From: Eleanor & Bill
Sent: Monday, September 29, 2014 9:41 AM
To: gef@portlandmaine.gov
Cc: cpizey@gmail.com
Subject: RoofDeck @ 7 Veteran ST. , Peaks Island, Me.

A structural visual inspection of the roof deck was conducted on 9/26/2014. There were no signs of any structural

Elevations

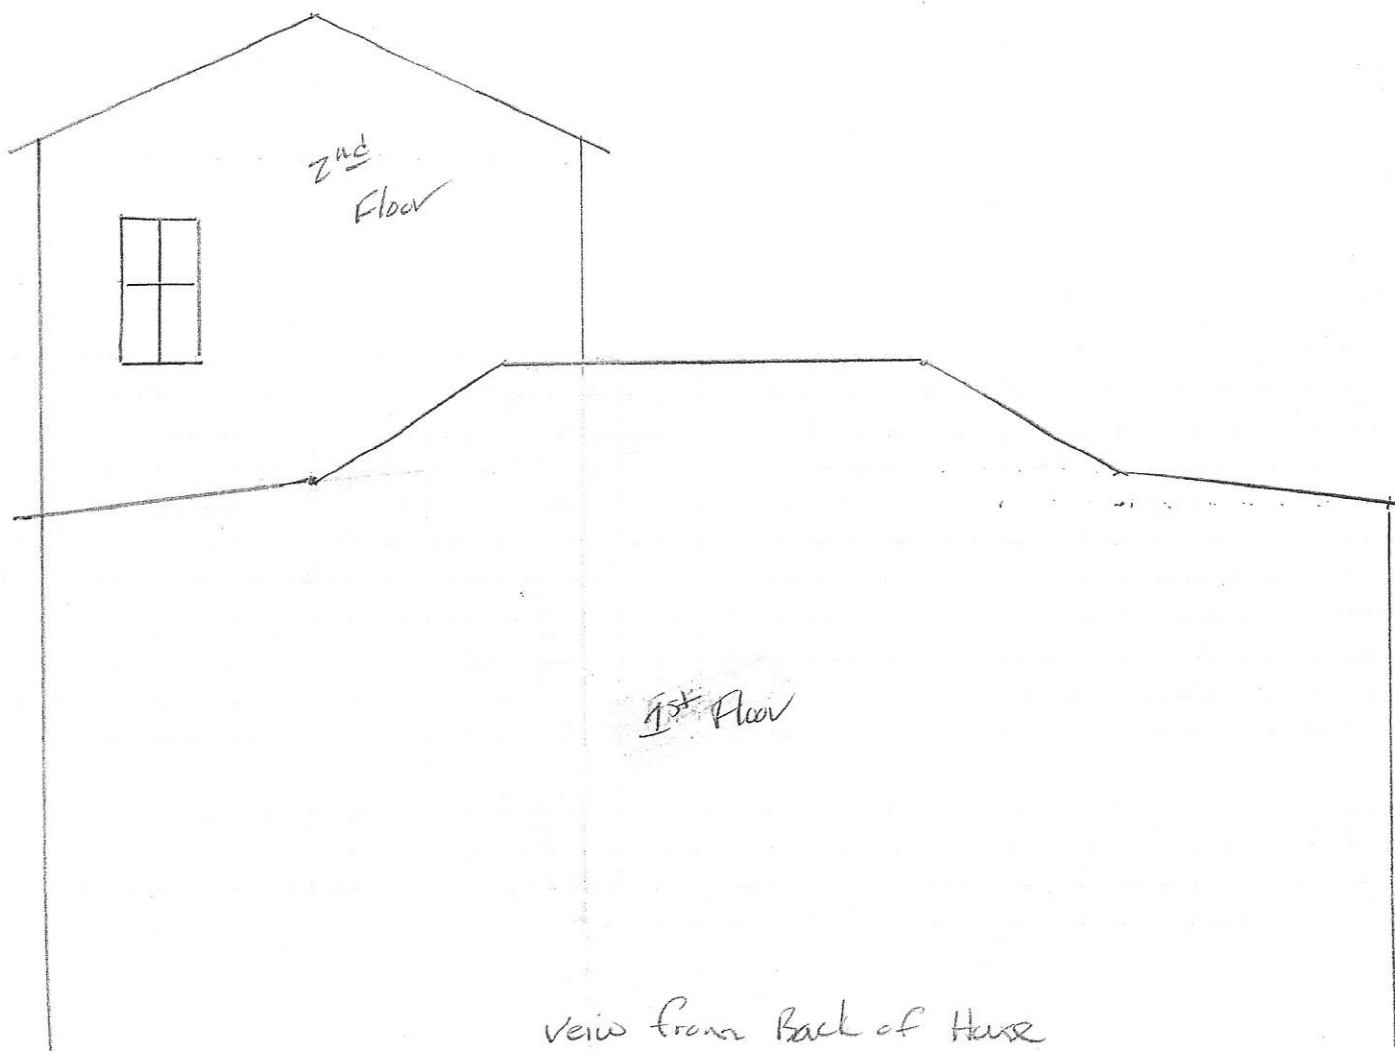
distress and the deck appears to be in good condition.

To further strengthen the header connection at the supporting posts and the house wall: Attach a 2x4 under the deck support header at each post. Shim and attach a 2x4 under the nearest

at the house wall. The 2x4 should extend down to roof pads at the posts.
